Your Ref:
Date: 13 September 2019

**The Great Yarmouth Third River Crossing Development Consent Order
Planning Inspectorate Case Reference: TR010043
Applicant's Response to Section 51 Advice**

Application Document Title and Reference	S51 Advice	Applicant's Response
Land Plans (document reference 2.5; PINS reference APP-010)	The boundaries of plot references 4-03 and 4-04, on Sheet 4, may be inhibited by the sheet's cut line. These are not shown on the adjoining sheet either and it would be worth making the boundaries clearer.	Issued as an electronic file via Sharepoint is the updated Land Plans document (document reference NCC/GY3RC/EX/004). This document includes Drawing No. GYTRC-WSP-LSI-XX-DR-GI-1017 Rev P01 Land Plans Sheet 4 of 9, which has been amended to move the continuation sheet text to the west side of the boundary of plots 4-03 and 4-04. It also includes Drawing No. GYTRC-WSP-LSI-XX-DR-GI-1015 Rev P01 Land Plans Sheet 2 of 9, to which labels have been added to show the location of plots numbered 4-03 and 4-04 to the east of the continuation line for Sheet 4.
Works Plans (document reference 2.6; PINS reference APP-011)	On Sheet 1, Work No. 2 is depicted using centre li

DRAWING TITLE
 DCO DOCUMENT 2.6
 WORKS PLAN
 SHEET 1 OF 7
 (REGULATION 5(2)(j))

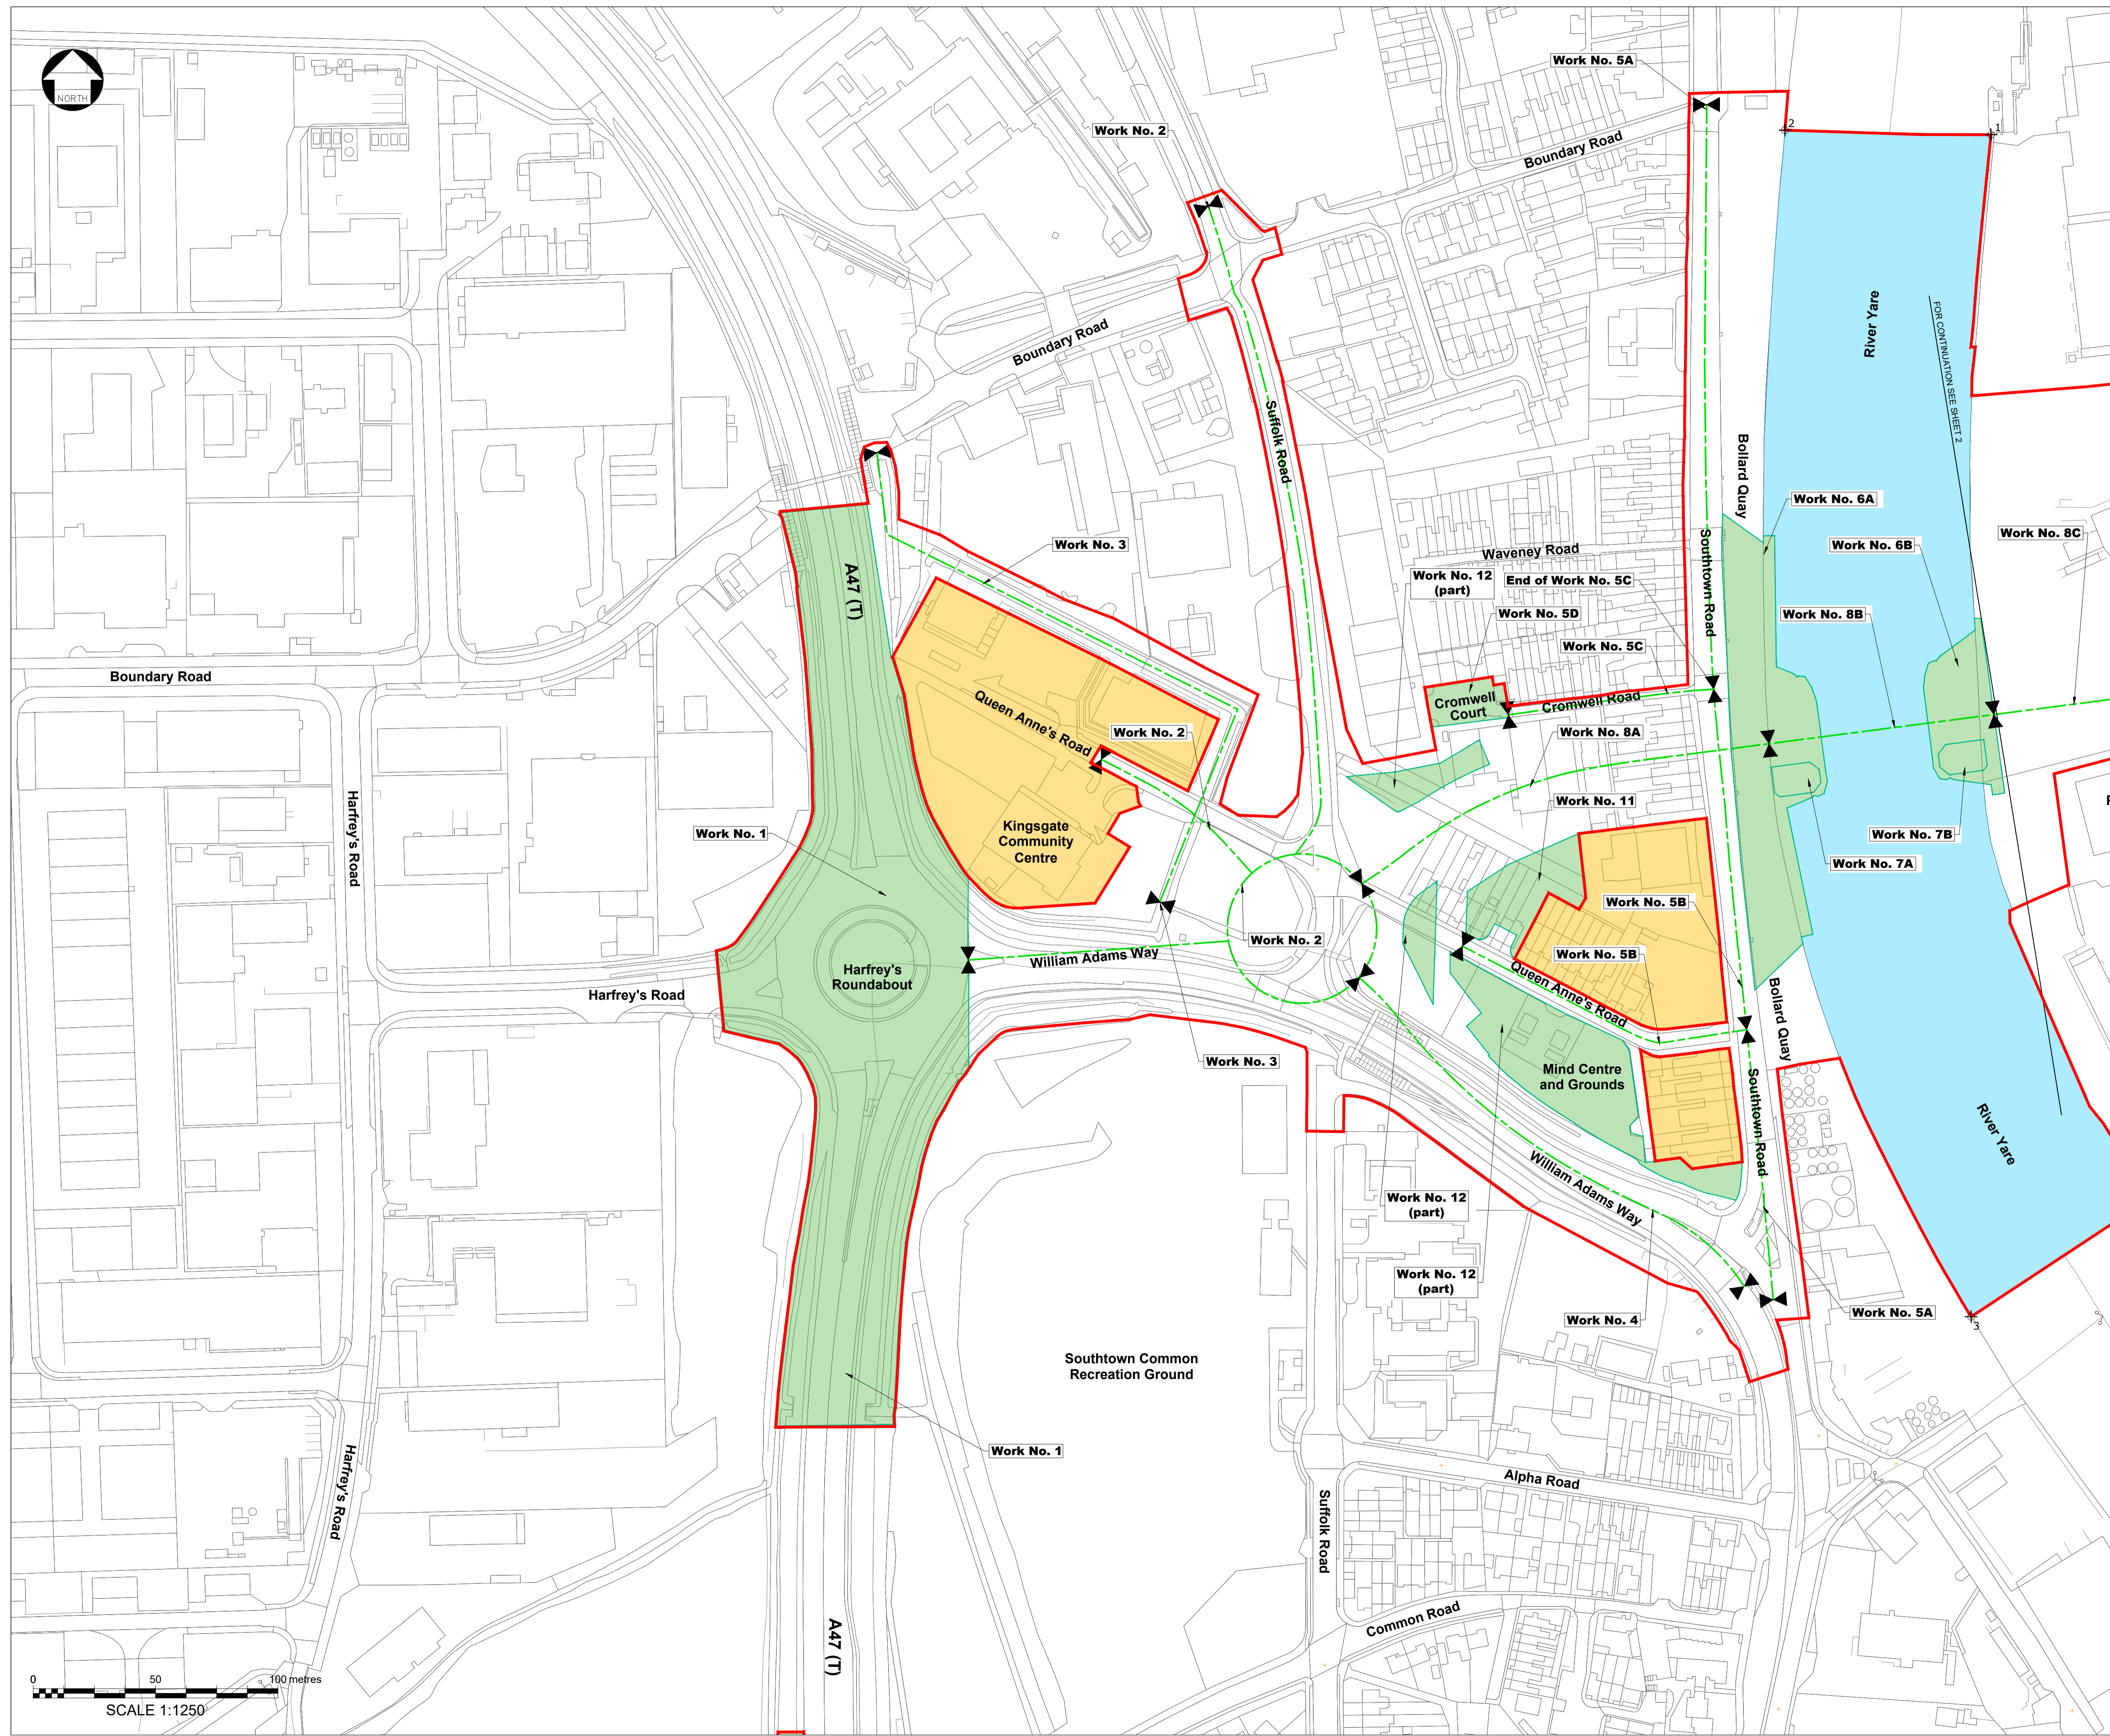
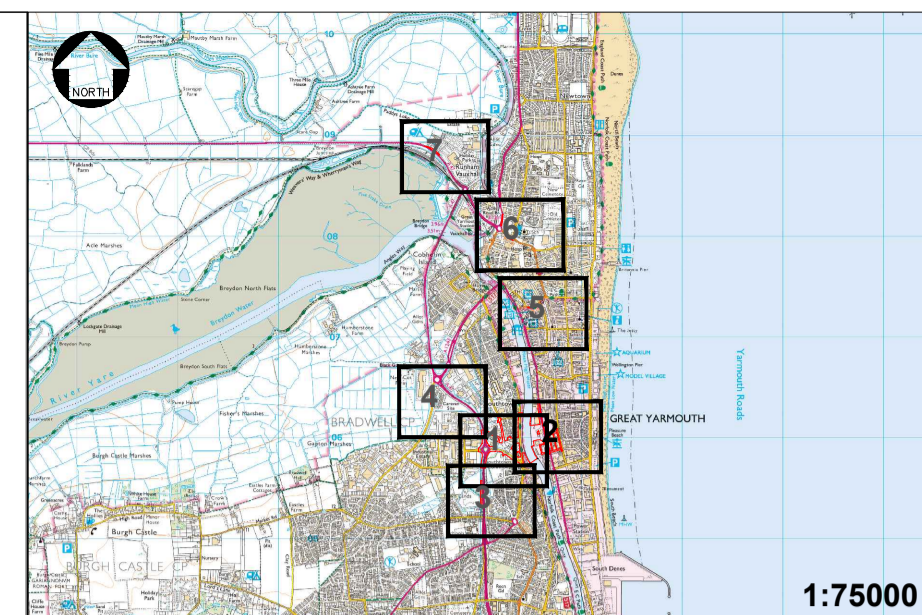
impacts, as set out in the Environmental Statement (document reference 6.1; PINS reference APP-096).
Works Plans (document reference 2.6; PINS reference APP-011)	On Sheet 1, Work No. 5b has two labels pointing to different roads; only one of the labels appears to match the description of the works in the DCO.	Issued as an electronic file via Sharepoint is the updated Works Plans document (document reference NCC/GY3RC/EX/005). This document includes Drawing No. GYTRC-WSP-HGN-XX-DR-CB-1024 Rev P01 Works Plans Sheet 1 of 7 and Drawing No. GYTRC-WSP-HGN-XX-DR-CB-1025 Rev P01 Works Plans Sheet 2 of 7, which clarify the locations of Work No. 5A and Work No. 5B through amended labelling.
Works Plans (document reference 2.6; PINS reference APP-011)	On Sheet 2, Work No. 9 is made up from 2 centre lines. These lines do not appear to be sufficient to depict all the works described in the DCO, particularly Work No. 9 c, d, e and f.	As required by the Infrastructure Planning (Applications: Prescribed Forms and Procedure Regulations) 2009, the Works Plans show linear features such as Work No. 9 by reference to a centre line and limits of deviation. The Applicant considers that when the Works Plans are read in conjunction with the other application plans and drawings, in particular the General Arrangement Plans (document reference 2.2; PINS reference APP-007) and Schedule 1 to the draft DCO, the works are described and shown with sufficient clarity.
